**FINAL DRAINAGE REPORT
FOR
NORTHGATE SUBARU
208 GLENEAGLE GATE VIEW
COLORADO SPRINGS, COLORADO**

FEBRUARY 2025

SF2510 and
PPR2514

NORTHGATE SUBARU COLORADO SPRINGS, CO PROPOSED DRAINAGE MAP JUNE 2025

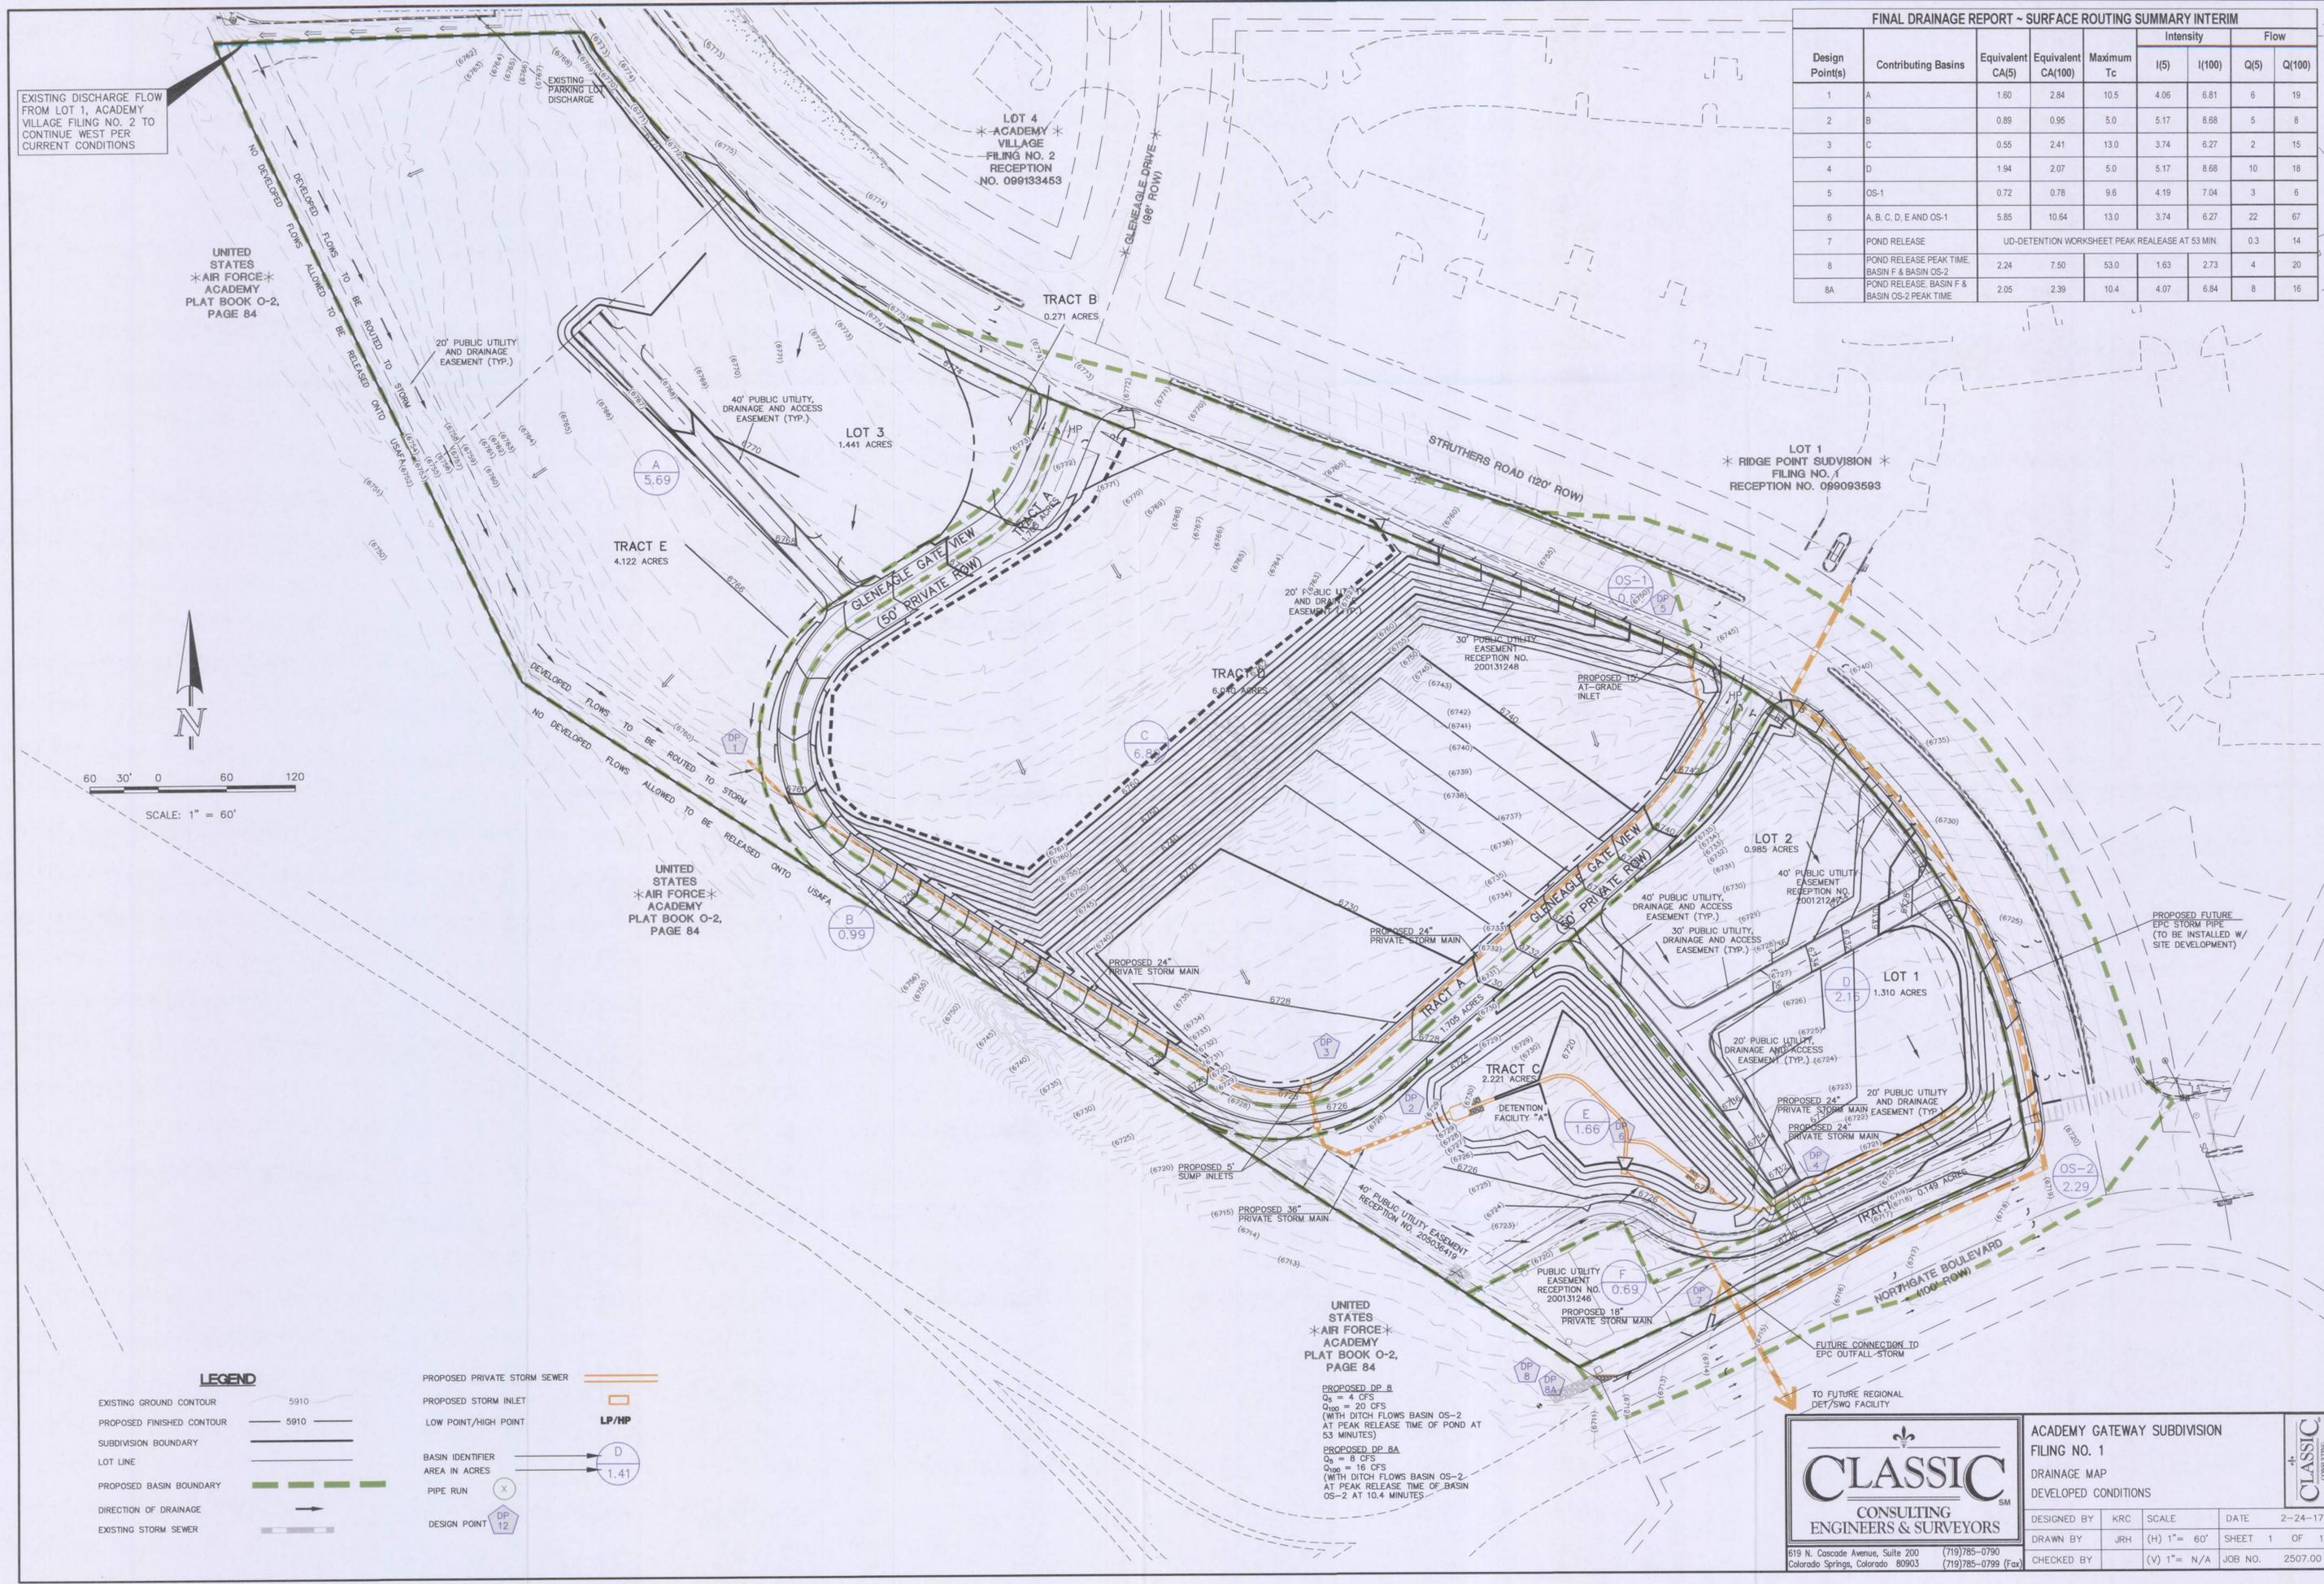
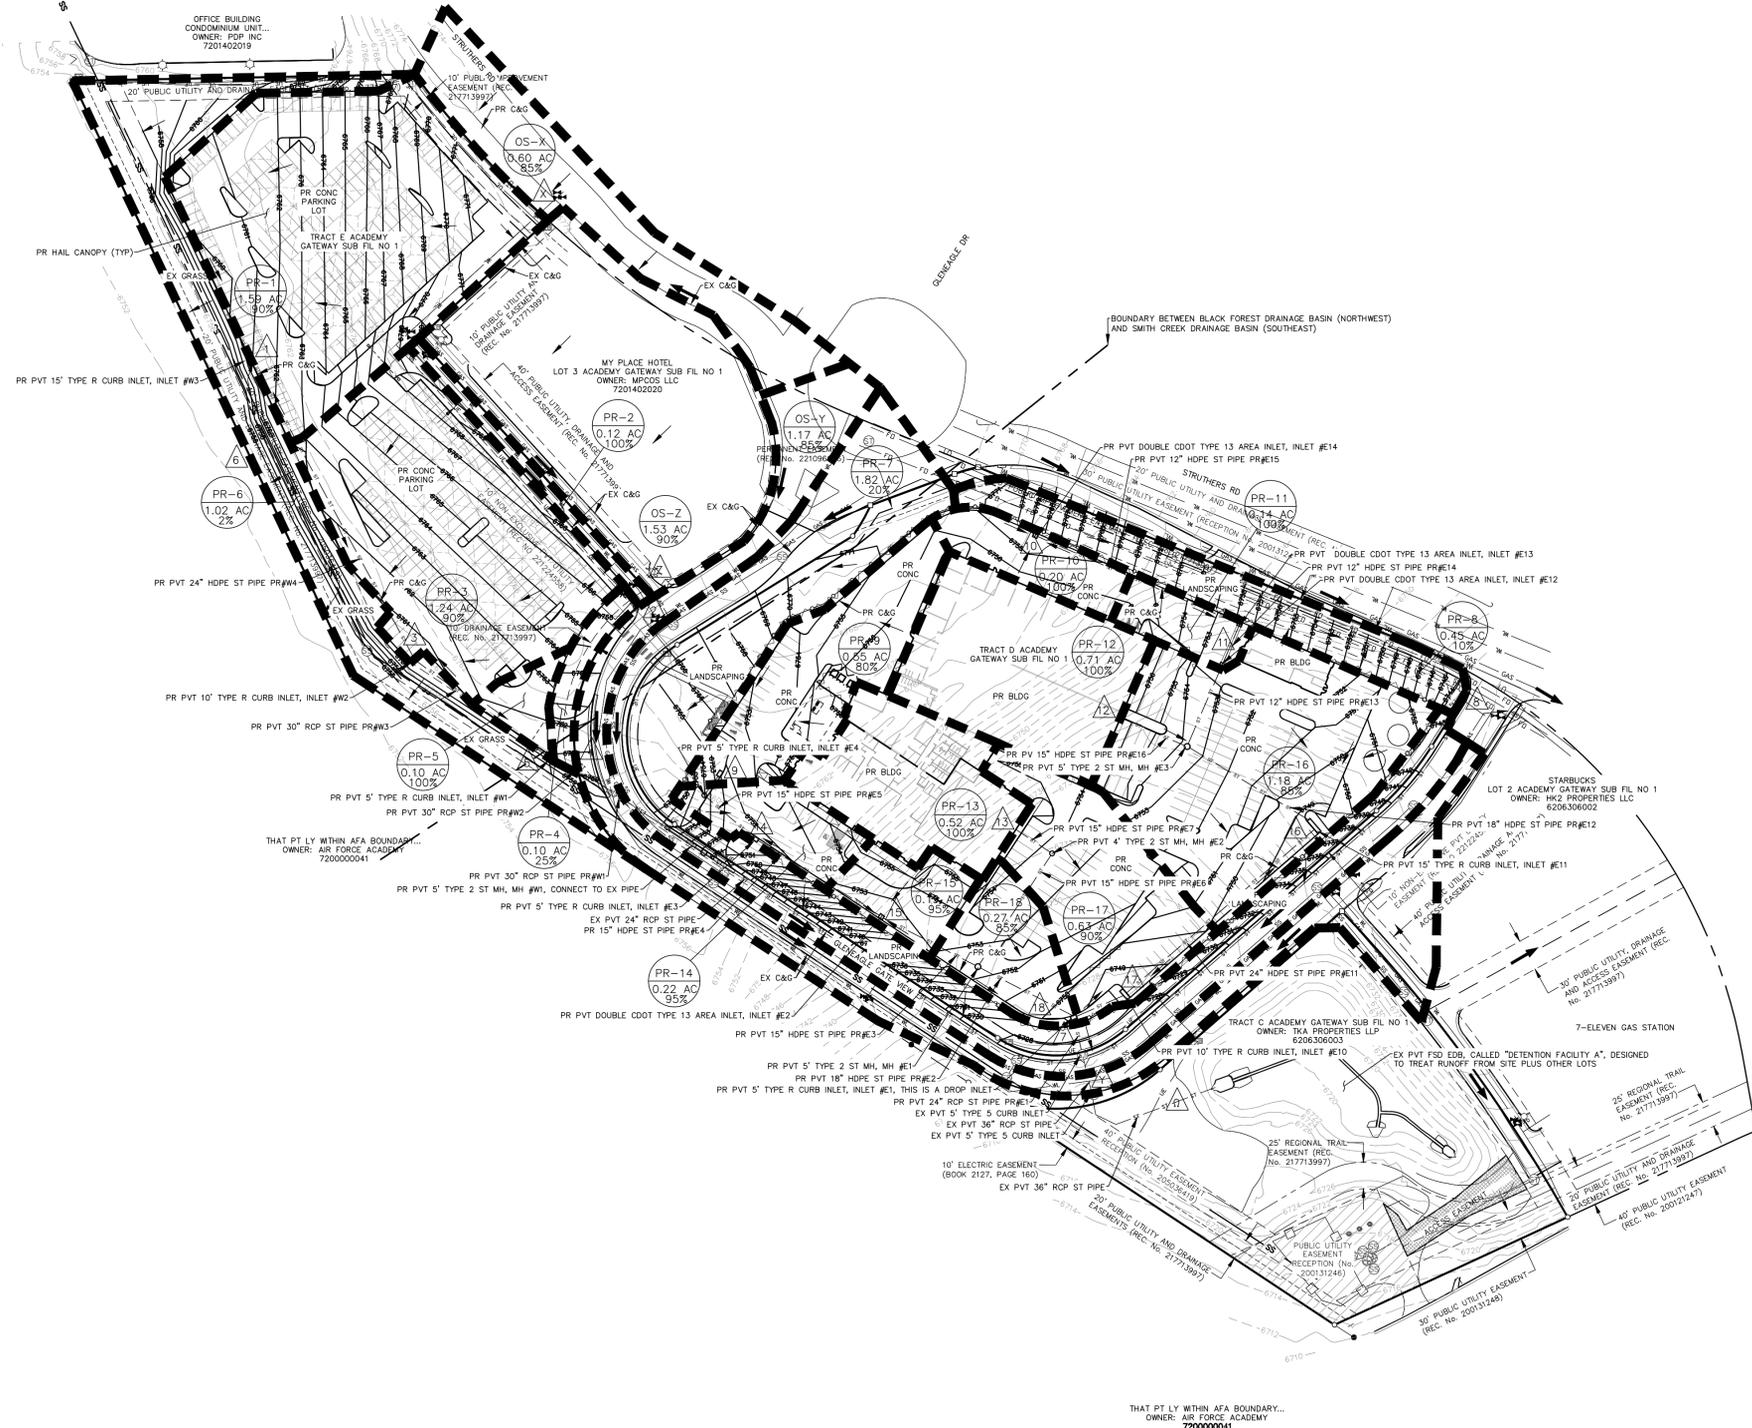
show fee basin boundaries
on the drainage maps

show basin boundaries on the drainage maps for Black Forest and Smith Creek

Provide design point flows for existing

Will need to be updated

TNE Response: It's already there.

TNE Response: It's already there, and even off to the side where it's easy to see.
